28 July 2016

File No: 2016/401214  
Our Ref: R/2015/18/A

**RE: LEES 1 Science Research and Teaching Facility (SSD 7054) and F23 Administration Building (SSD 7055) – The University of Sydney**

2:00 PM - 22 DECEMBER

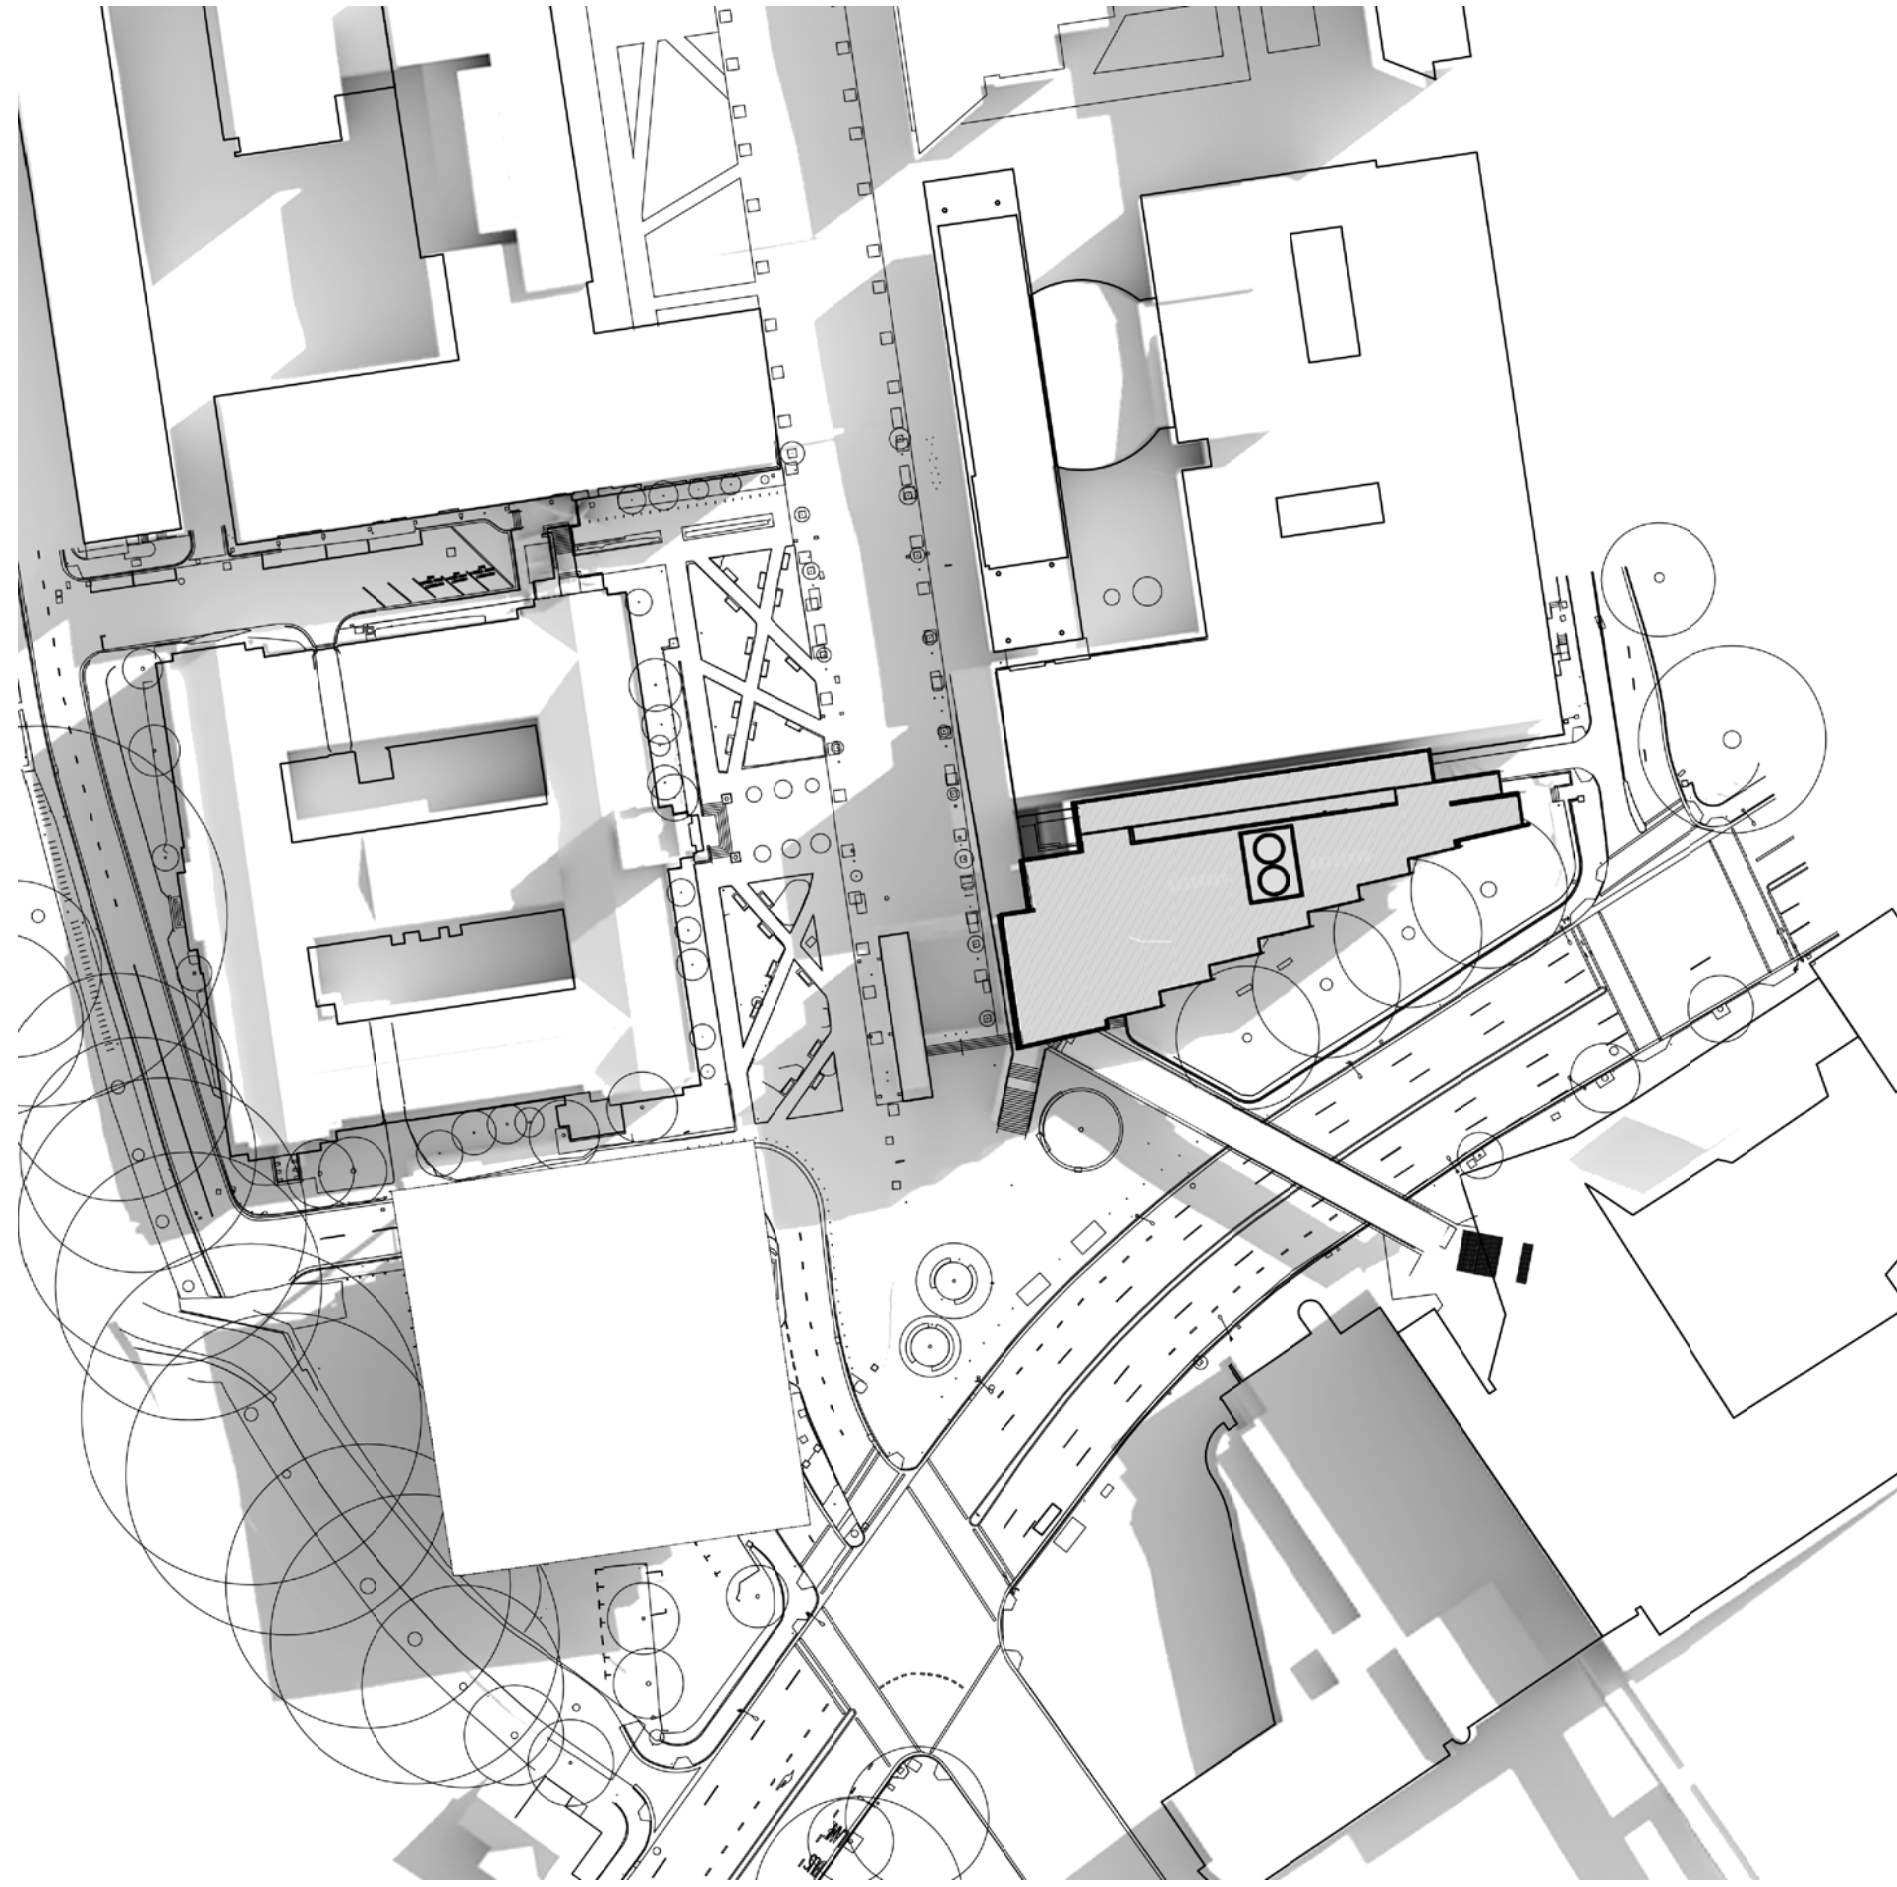
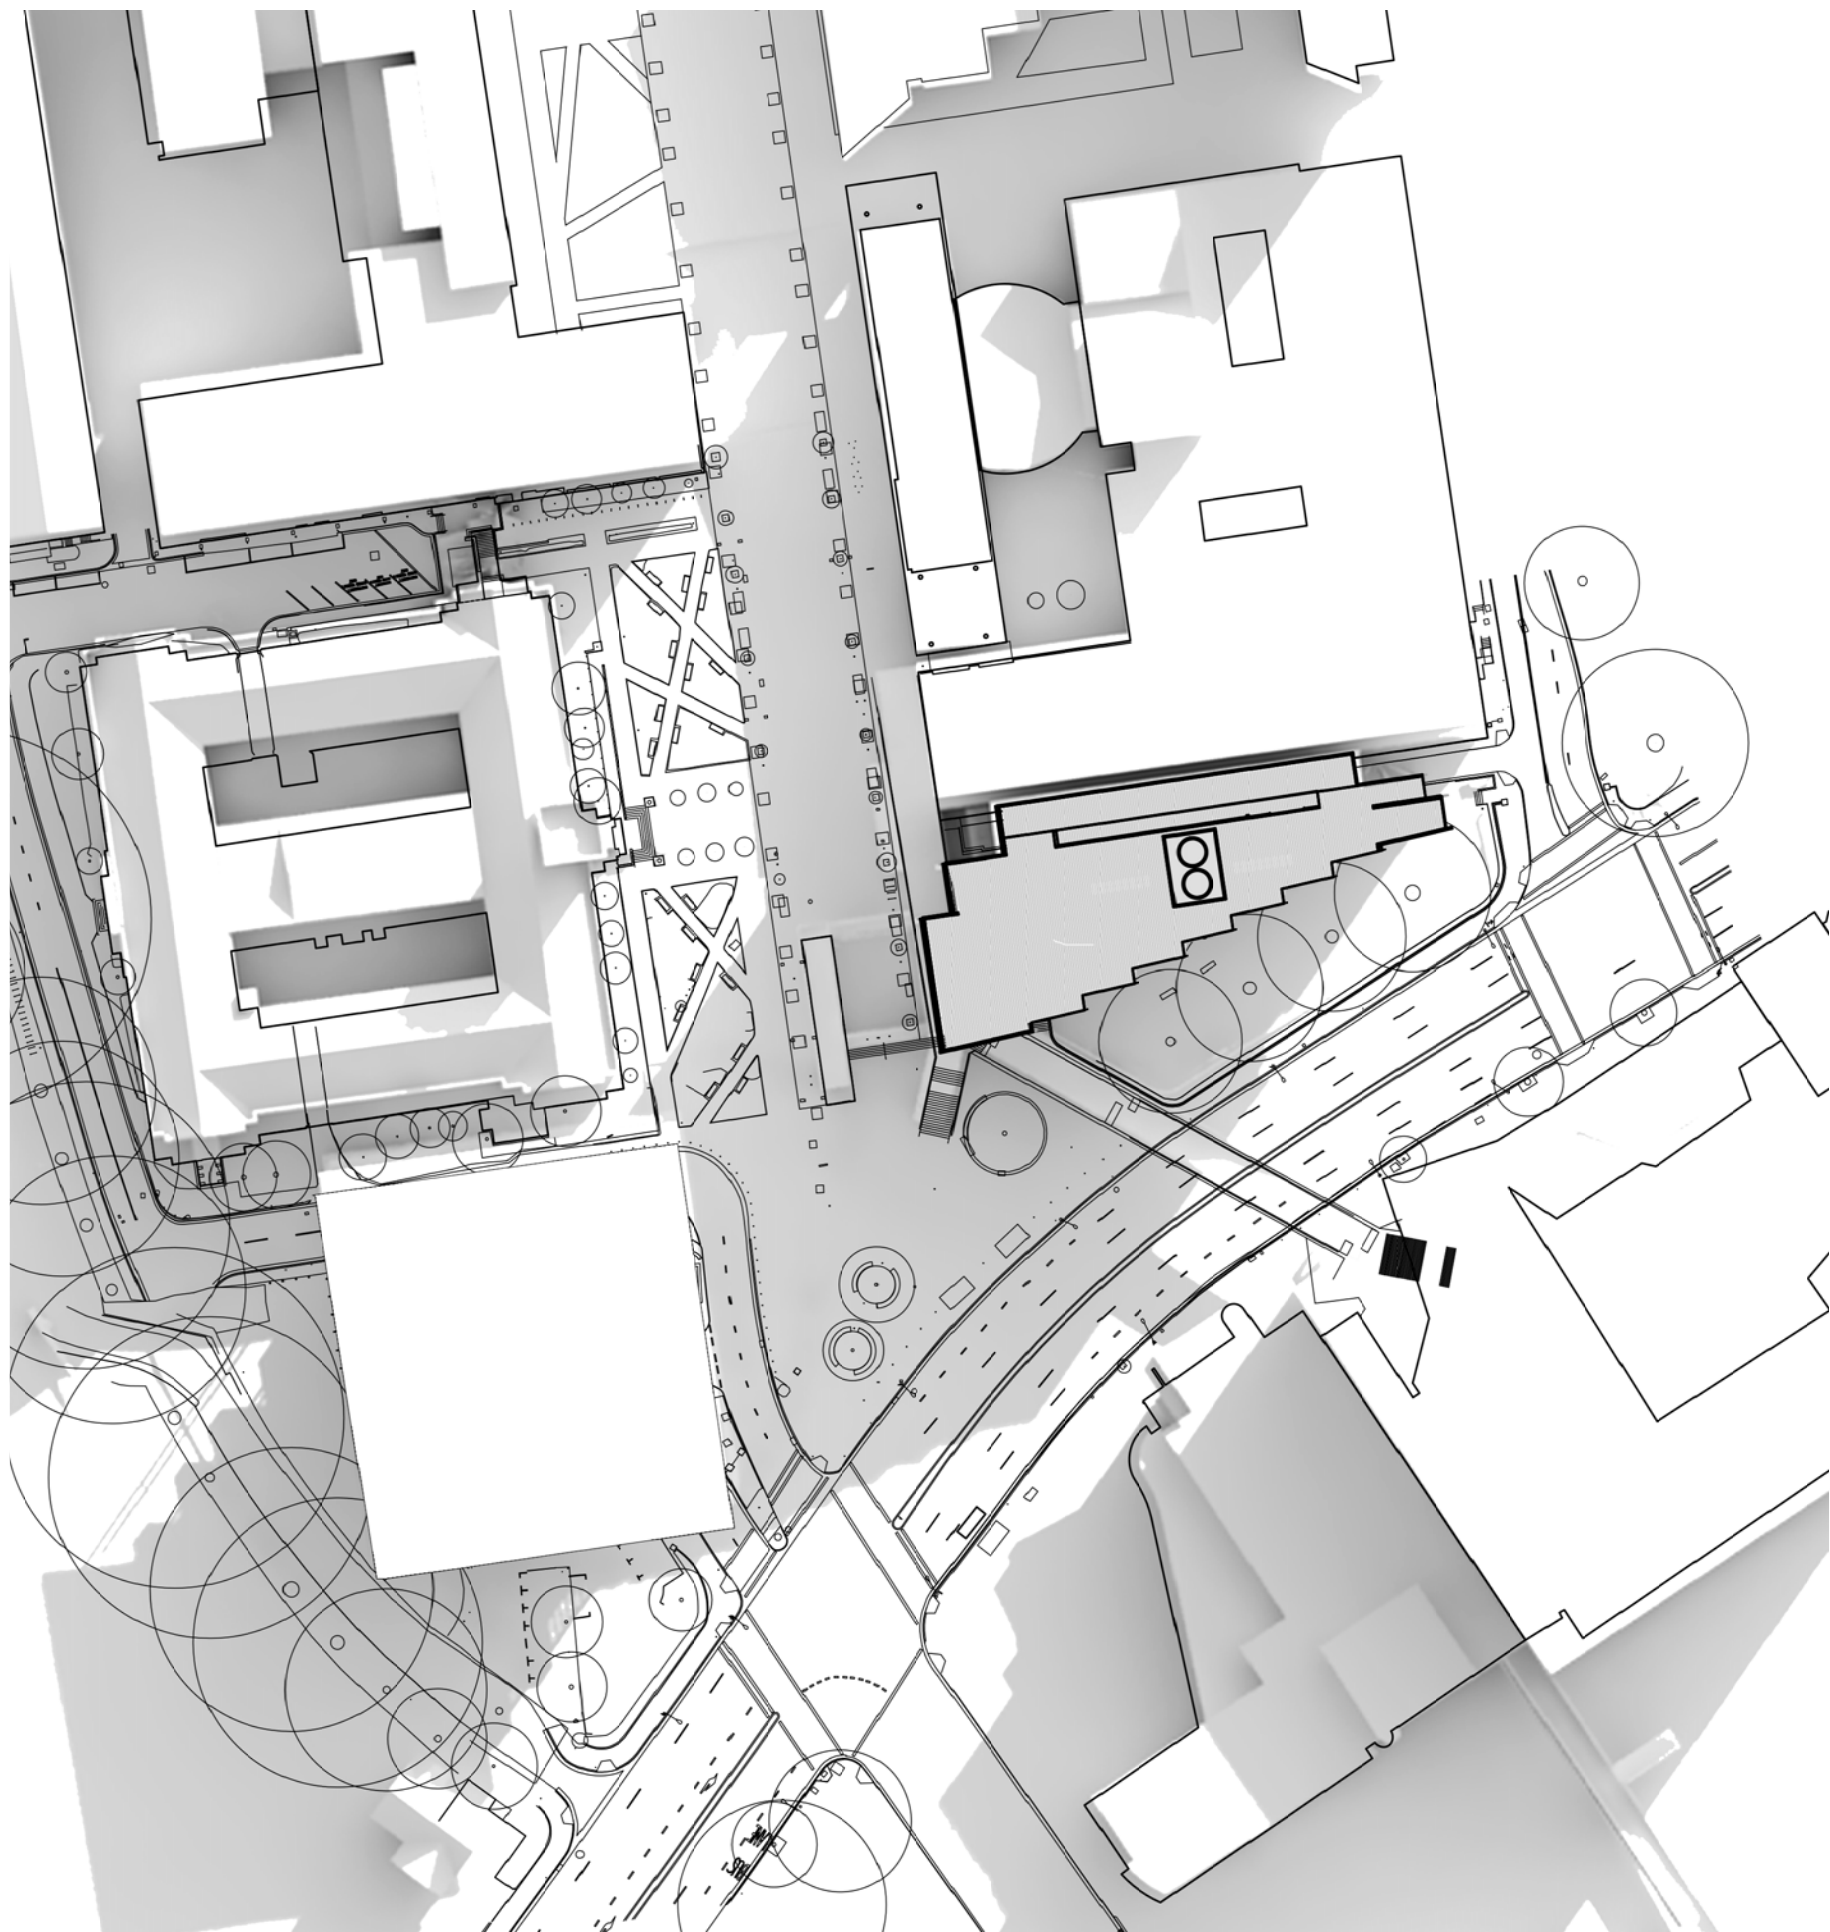
Detailed diagrams are required to differentiate the existing shadow from that of the shadows cast by the proposal. The diagrams illustrate significant overshadowing of the existing (retained) Fig trees along City Road between midday and 3pm. This is likely to result in adverse impacts upon tree health and longevity.

Shadow impacts upon the Sydney University Building on the southern side of City Road are also indicated in the drawings. The extent of this overshadowing is unclear.

NOTE: REFER TO AIA PREPARED BY TREE IQ

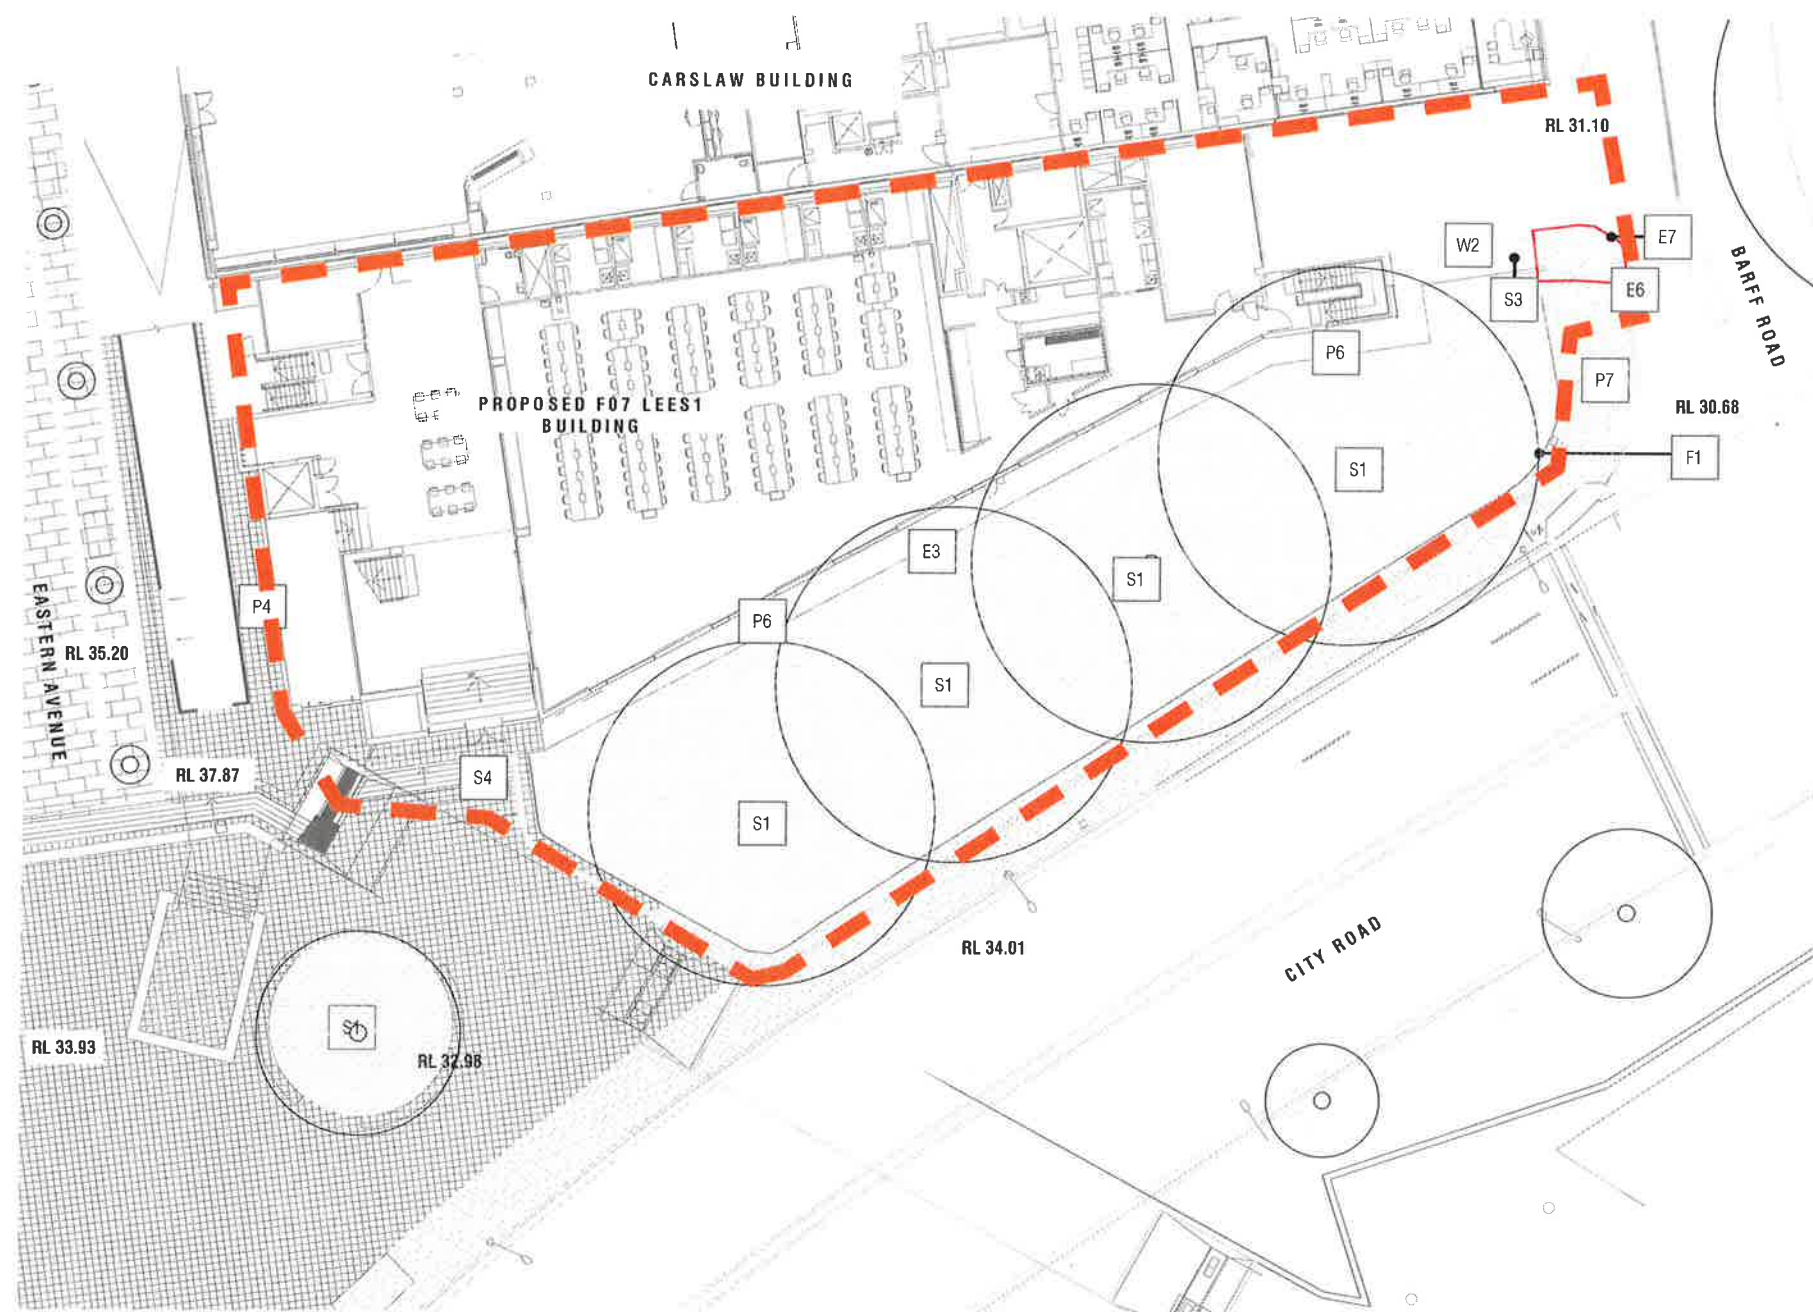
To minimise the impacts of the new building on the significant fig trees, it is recommended that the building is setback further from the trees to allow a minimum distance of 2 metres from the edge of the existing canopy. This allows for scaffolding to be located within a 1 metre zone from the final edge of the building façade. Further, once the construction is complete it allows the tree 1 metre for growth, and 1 metre for clearance of the building facade. An accurate survey of the tree height, spread and crown shape should be undertaken and overlayed onto the proposed plans to ensure the setback is sufficient from the existing significant trees.

Subsequent to the resolution of the above, and due to the sensitivity of the existing Figs, the existing understorey planting should also be retained and protected.
